Application for a non-material amendment following a grant of planning permission.

The erection of a Mansard Roof Extension

Reference number: APP/X5990/D/20/3247628

The amendment is to lower the cill of the window that is located in the stairwell on the rear elevation to allow for a clear opening of 1sqm.

REV	DATE	NOTES	INT	PROJECT TITLE
00	15.06.21	SUBMITTED FOR NMA	-	54 SUSSEX STREET
DRAWING TITLE				DRAWN
ROOF EXTENSION WINDOWS				FW
DRAWING NO.				CHECKED
A-20002-2011				FW
				SCALE
				1:20@A1
				REVISION
				00

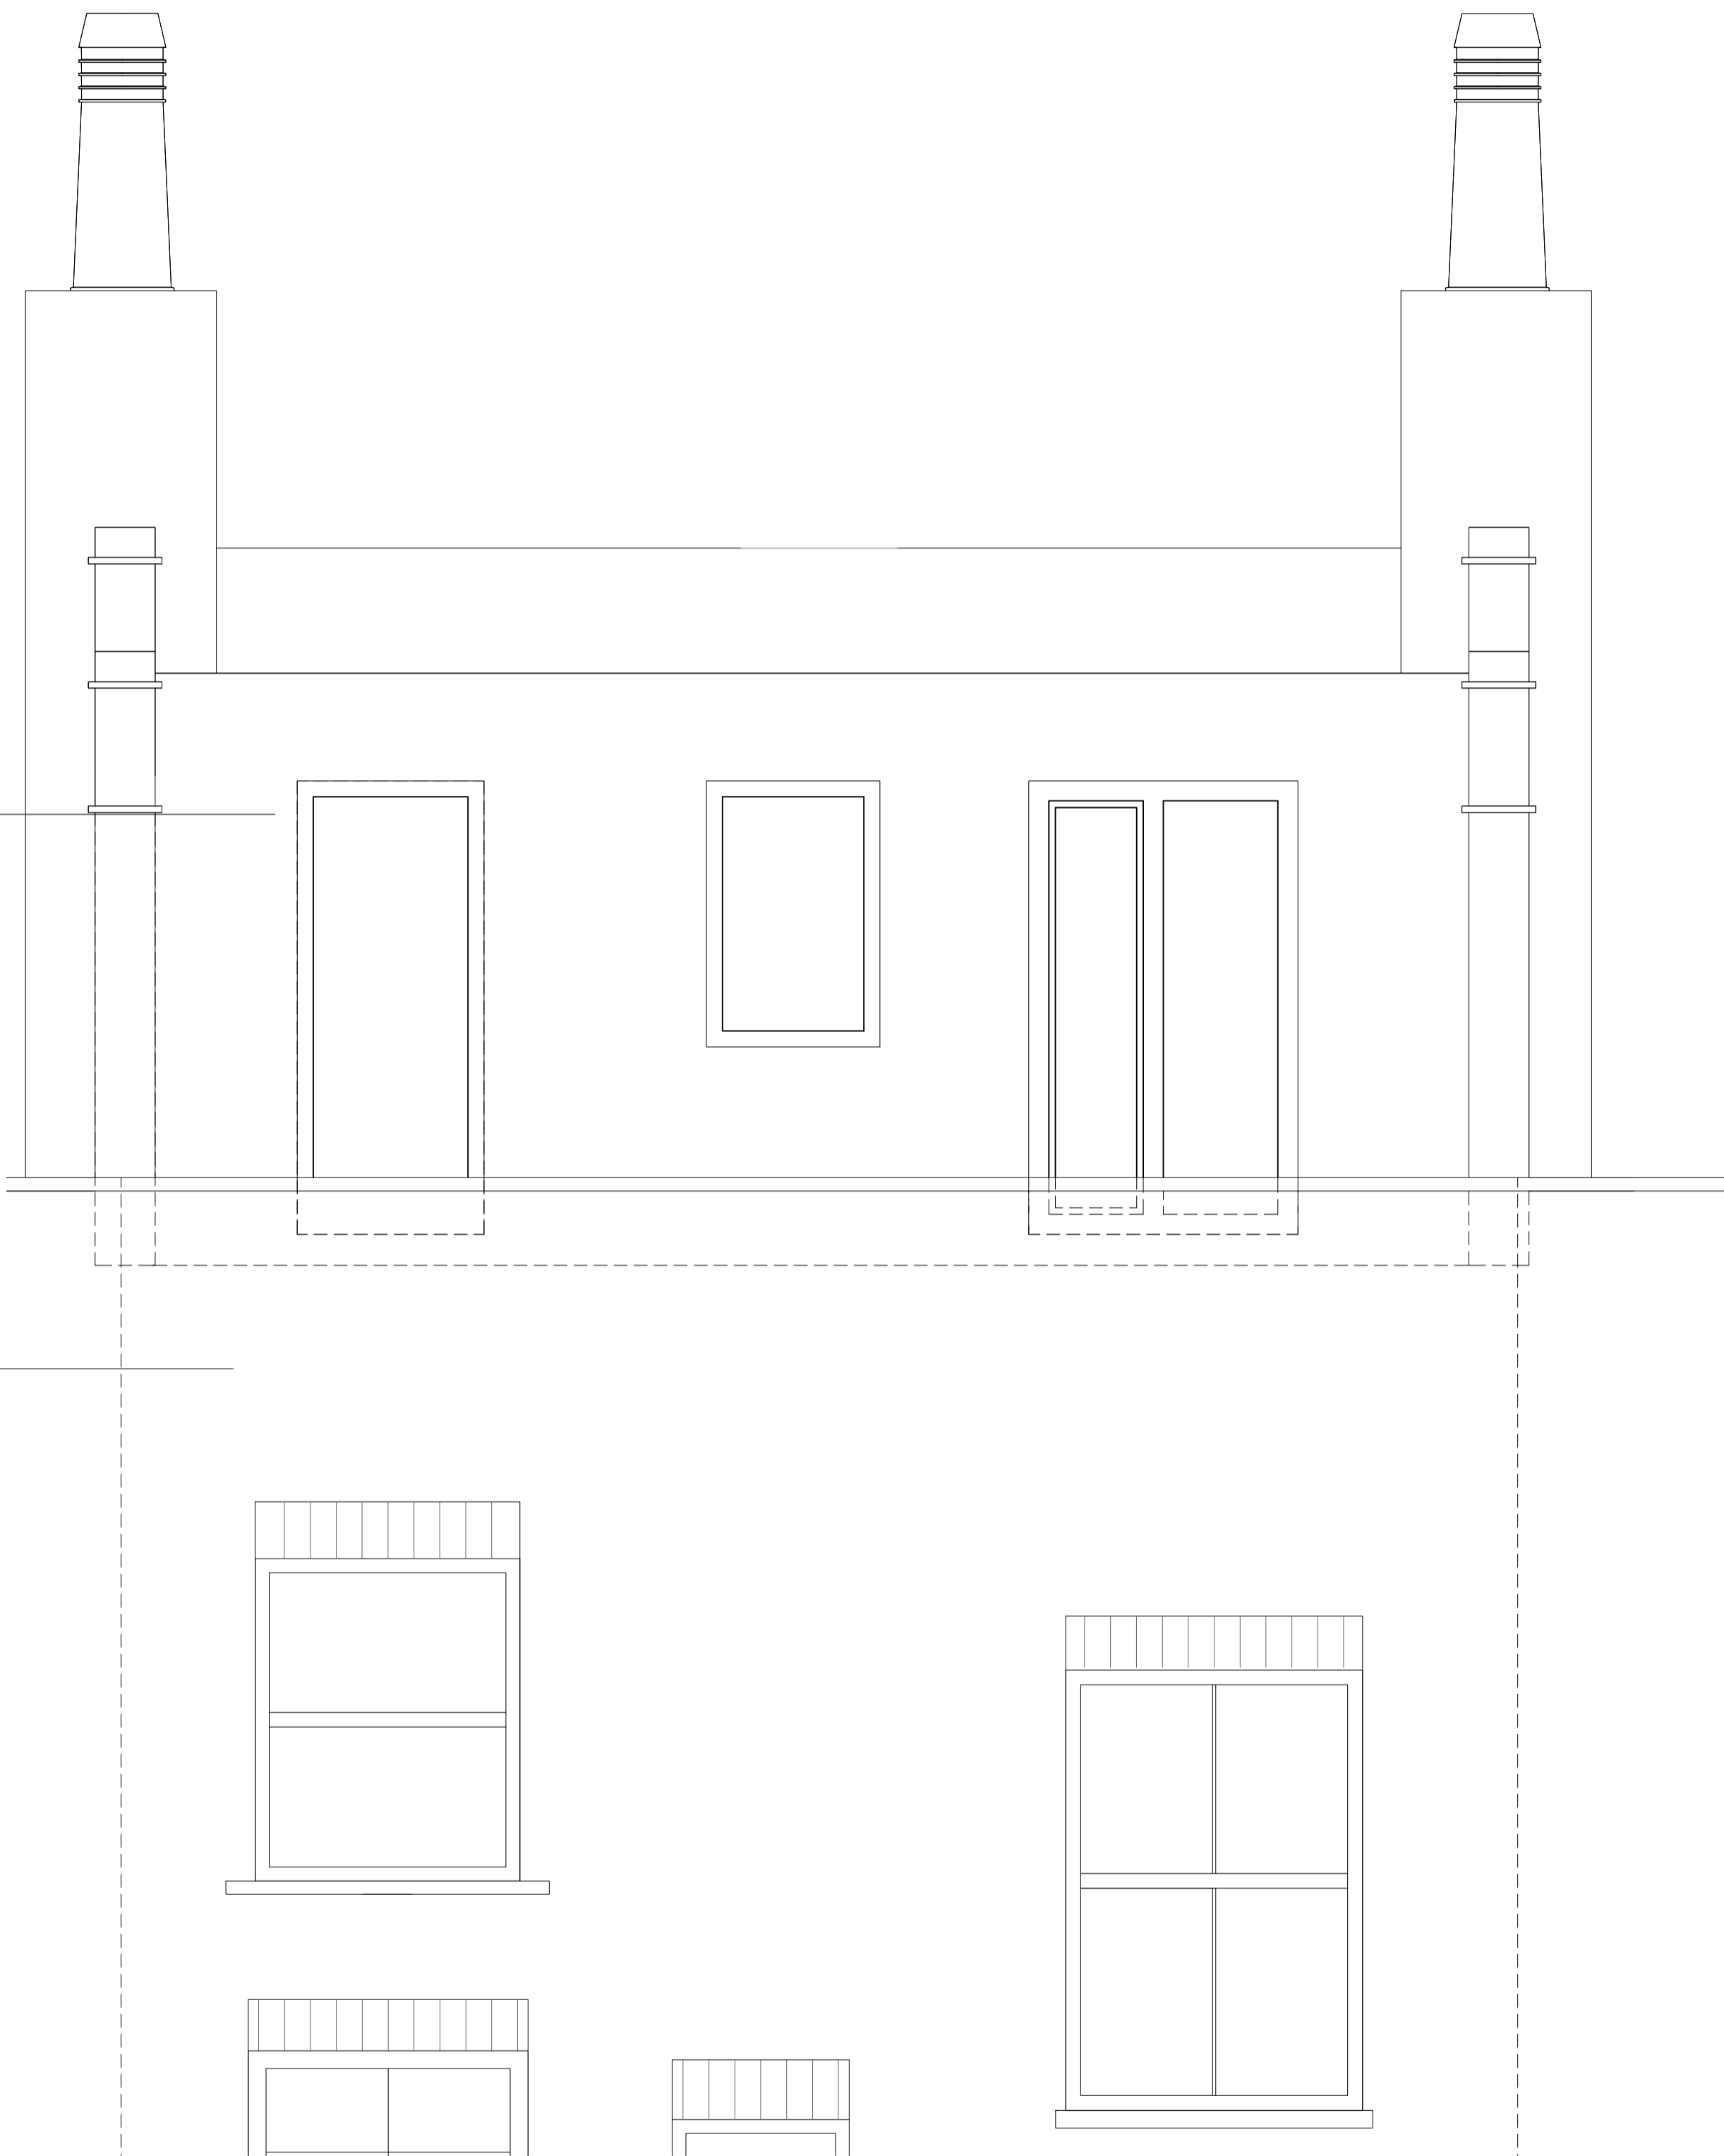
The amendment is to abide to the fire regulations, allowing for a window with a clear opening of 1sqm to be provided at the top of the stairwell to allow for the egress of smoke from the building should a fire occur. This window will be fixed, apart from when a fire occurs.
